From:
Sent: 11 September 2023 09:13
To: DCAdmin
Subject: Building off Greenacres Close, Emley

Comments in relation to the following applications by Newett Homes;
2023/92255 Land at Green Acres Close, Emley, Variation of Conditions 1 (Plans) , 2 (Crime Prevention) and 15 (Permitted Development) of Previous reserved matters approval 2021/93286 pursuant to outline permission 2020/91215 And
2023/92327 Land at Green Acres Close – modified plans for 6 Dwellings plus parking and landscaping and modified plans for ball stop netting.
And
2023/92254 Land at Green Acres Close – Discharge of conditions 6 (Drainage) 14 (CEMP) And
2023/92253 Land at Green Acres Close – Discharge of conditions 6 (Highways) 7 (PROW) 10 (CEMP) 11 (Drainage) 27 (Ball Stop Netting)

2023/92255 and 2023/92327 – Plan modifications

Proposed Section 104 Plan (1:250)

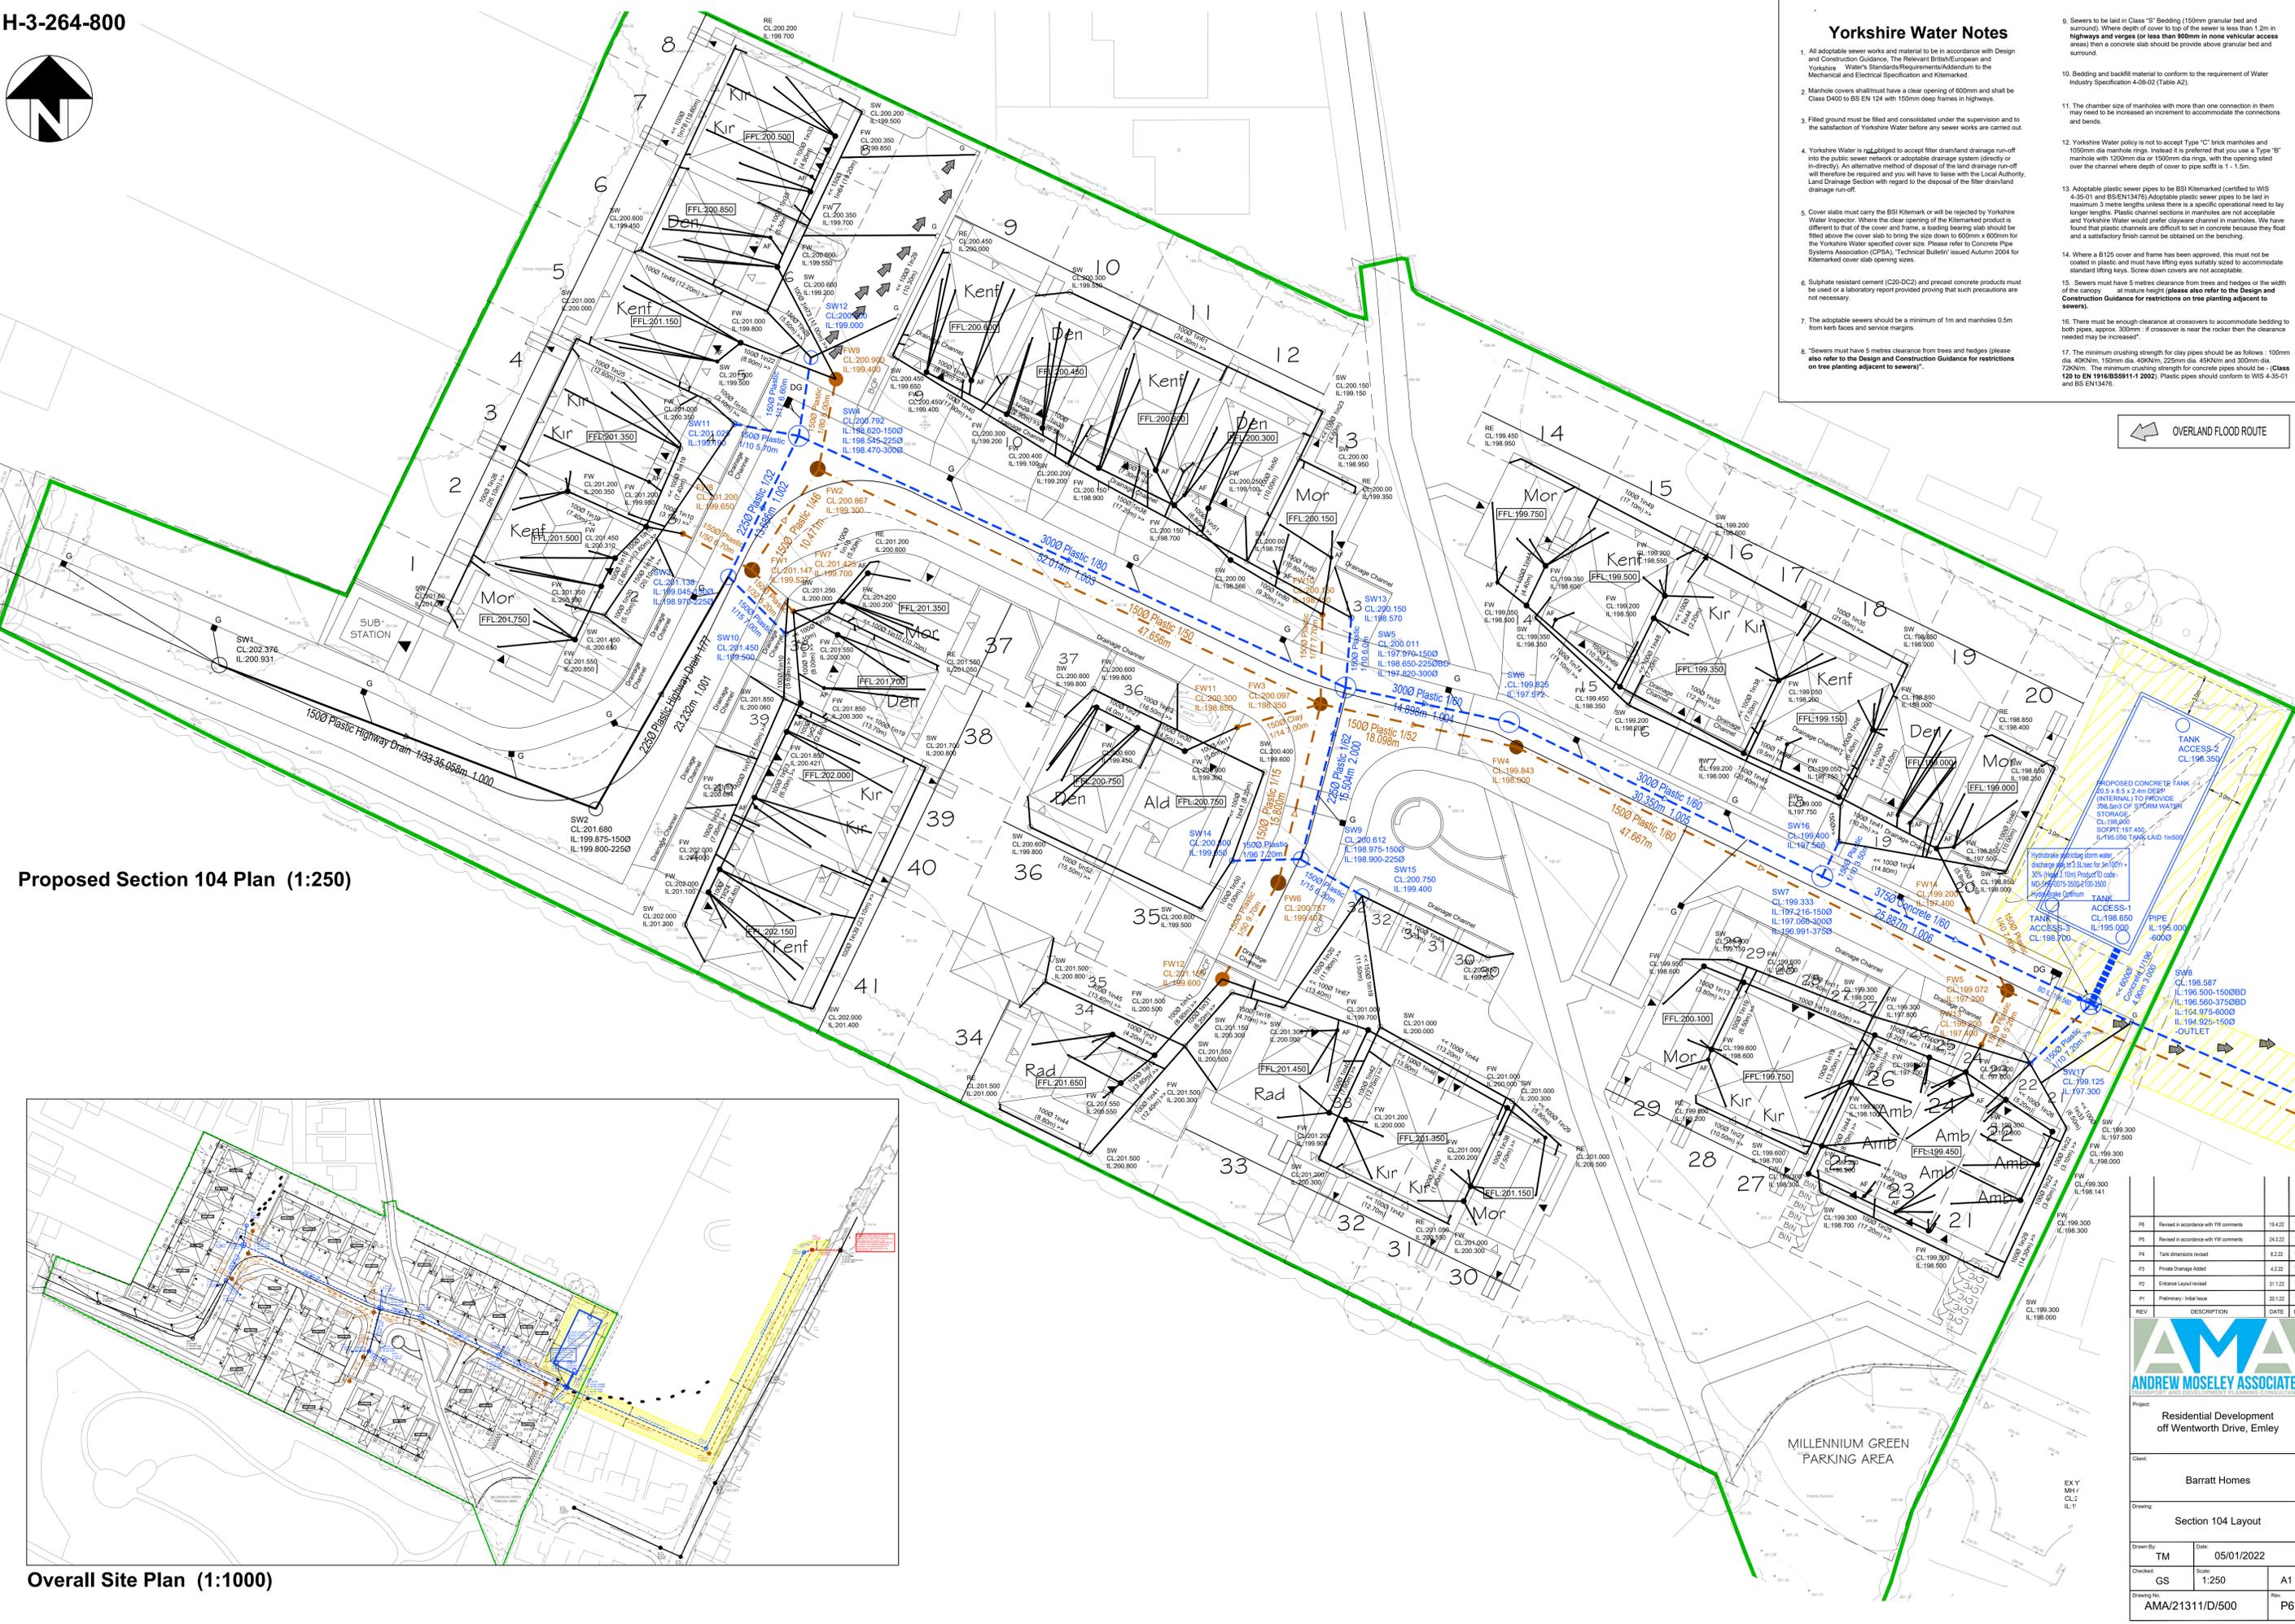
Newett Homes have submitted plans for temporary drainage that will affect the parking area and entrance to the Emley Millennium Green – Any drainage plans that affect the parking area or entrance must be discussed and agreed with the Trustees of the Green and must not block or impede the area at any time.

CONSTRUCTION ENVIRONMENTAL MANAGEMENT PLAN REV C

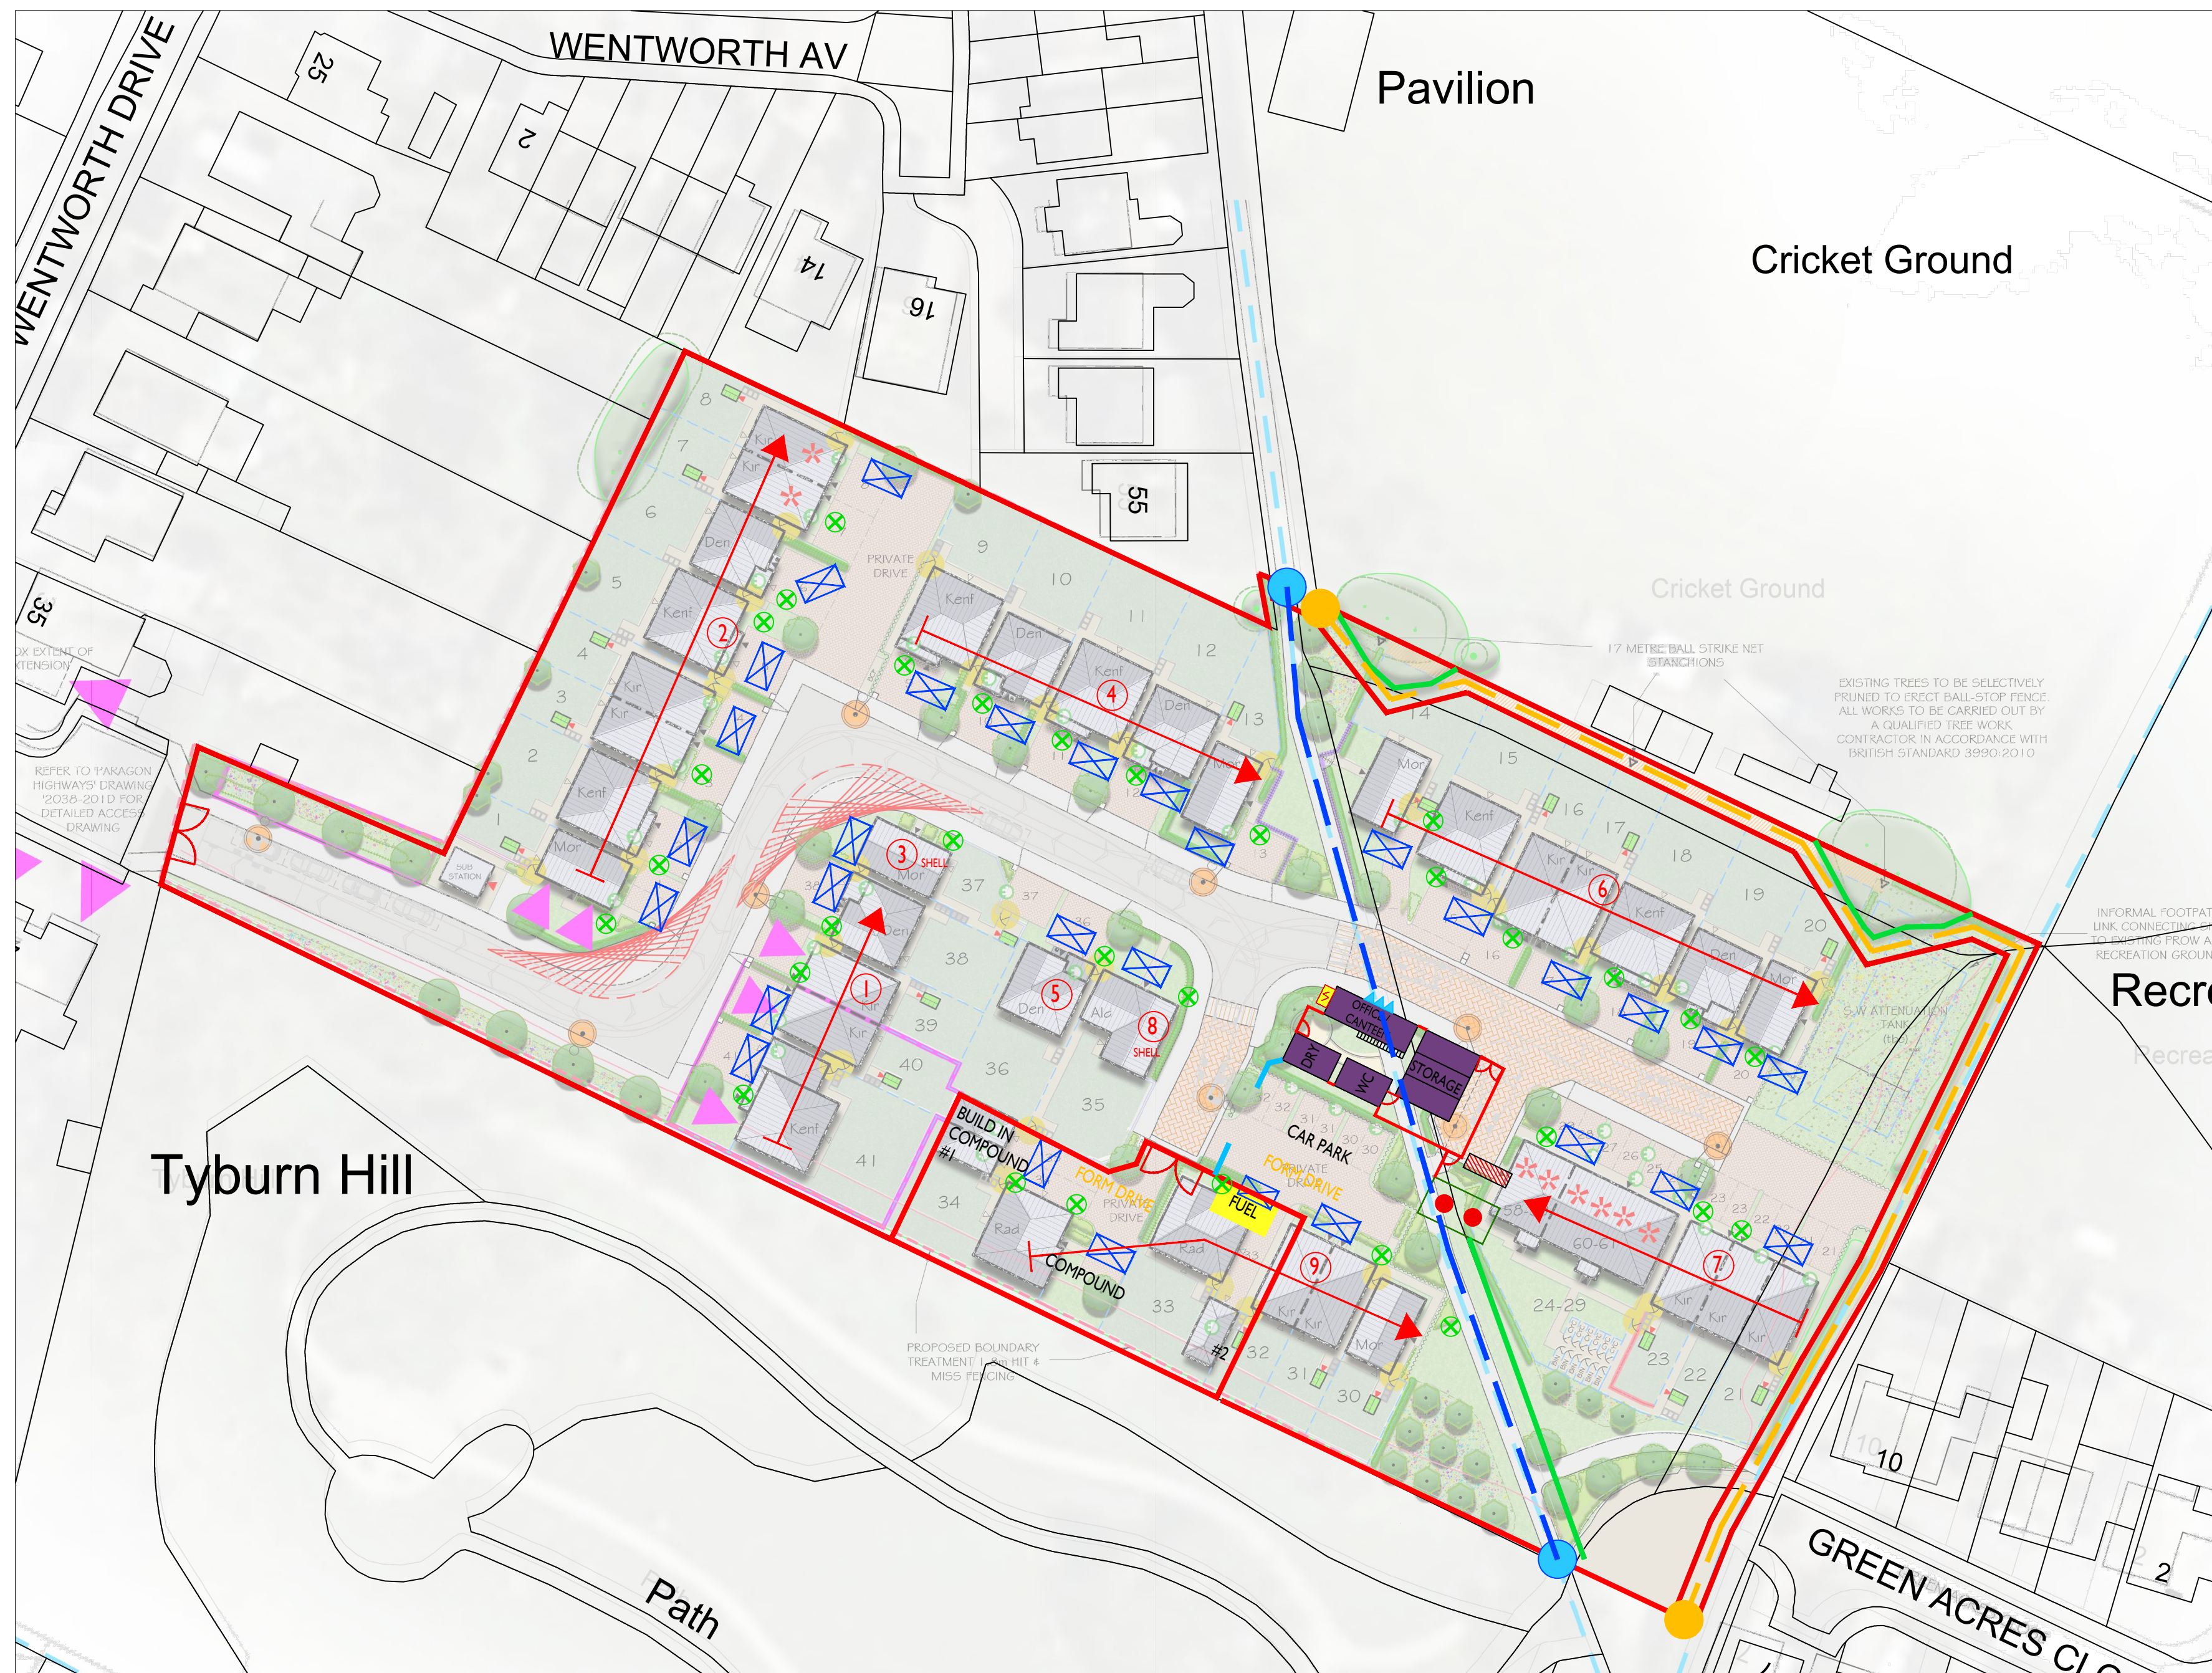
1 - How do Newett Homes propose to protect the Millennium Green's trees, bushes and wildlife during the development from construction debris, dust and mud, from excess construction noise and artificial lighting. The Millennium Green is used for the release of recovering hedgehogs from the nearby hedgehog hospital. Newett Homes is aware of this and has been approached by the hedgehog hospital with a request to enter the development

site to monitor and/or re-home such hedgehogs who may be along the boundary and within the development site. Newett Homes needs to factor this into any of their construction management plans. There also needs to be suitable protection of tree roots on the boundary of the Millennium Green throughout the development phase.

2 – How will Newett Homes ensure access to the Emley Millennium Green and other public areas are not impeded during the development.

6 – Parking of construction workers vehicles will be an issue, what are the plans?

7 – Reassurance that the access from Green Acres Close will not be used by construction workers or deliveries.
